REPORT UPDATE

Application No: AB/57/13/A

LOCATION: Martin McColls
5 High Street
Arundel

PROPOSAL: 2 No. fascia signs to East & South elevations

Client	McColl's
Address	6242 Arundel
Project	New signage
Issue No.	07
Date	05-06-13
Scale	
Drawn	Chris Szramek
Approved / Date

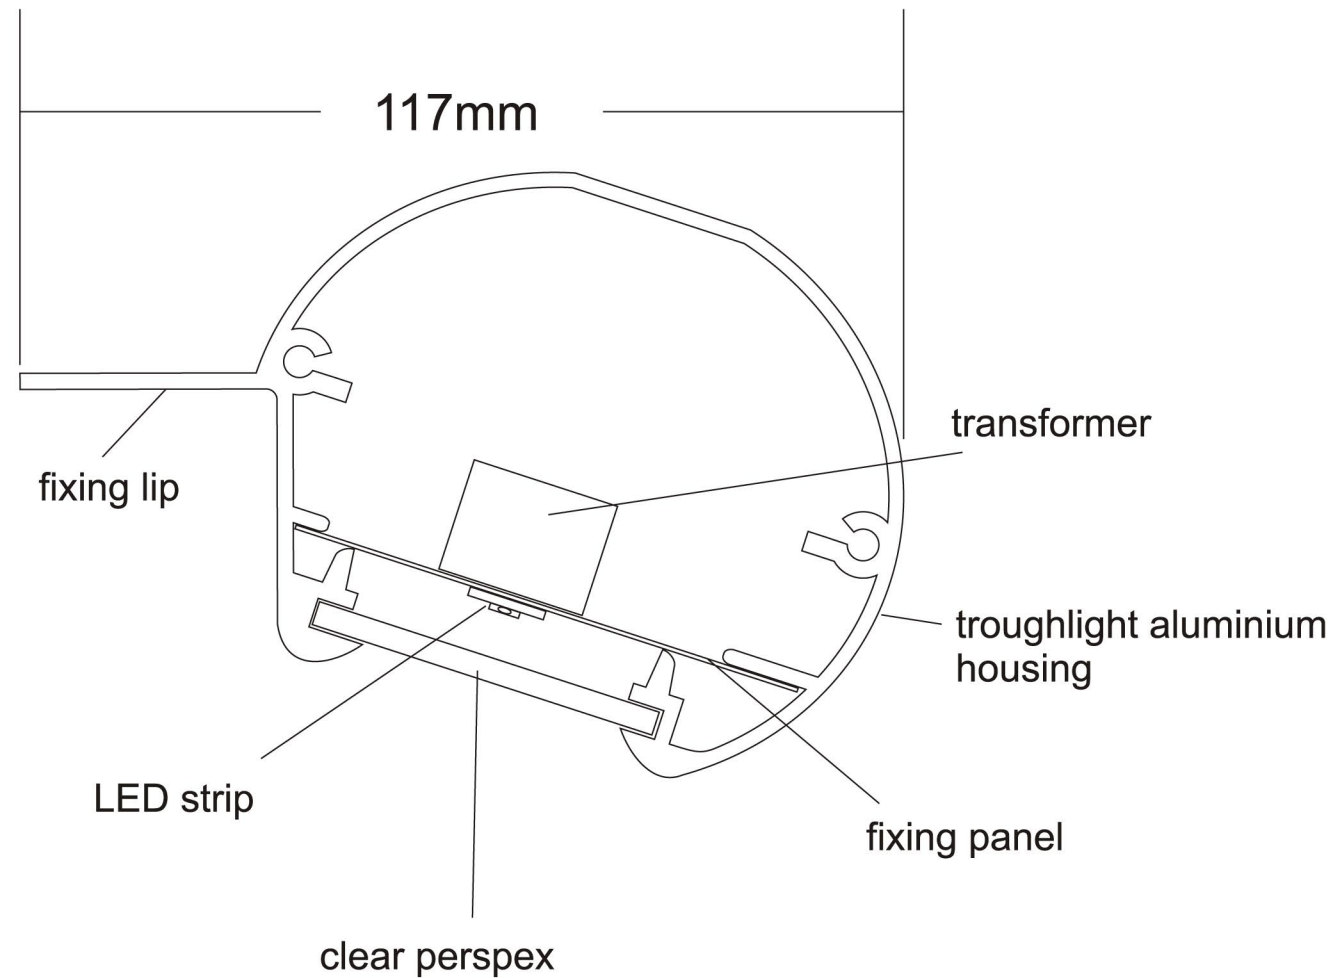
Second Consultation following amendment (removal of illumination): Serious objection to the fascia name sign as it is not in keeping with the building nor for the historic area that it is in, which requires a subtle and environment conscious approach to signage.

The application originally submitted included provision of external illumination for the fascia signage. It was felt that illumination of fascia signs of this size would be unacceptable due to the historic nature of the town centre, which is a designated conservation area, reflected by the lack of illuminated fascia signage on neighbouring shop fronts. The applicant was informed of these concerns and, subsequently, removed the illuminated element of the scheme.

The fascia signage is already in-situ. It is considered to be of a simple design and, by virtue of this, it does not appear as a garish or over prominent feature within the Conservation Area nor has it detracted from the appearance and special character of the building to which it is attached. The signage clearly integrates with the general pattern of non-illuminated fascia advertisements that are prevalent on the shop fronts of surrounding buildings.

- 6 INFORMATIVE: This approval is granted on the basis that the advertisements are not illuminated, as agreed by the applicant and confirmed by E-mail received on 23rd of July 2013.
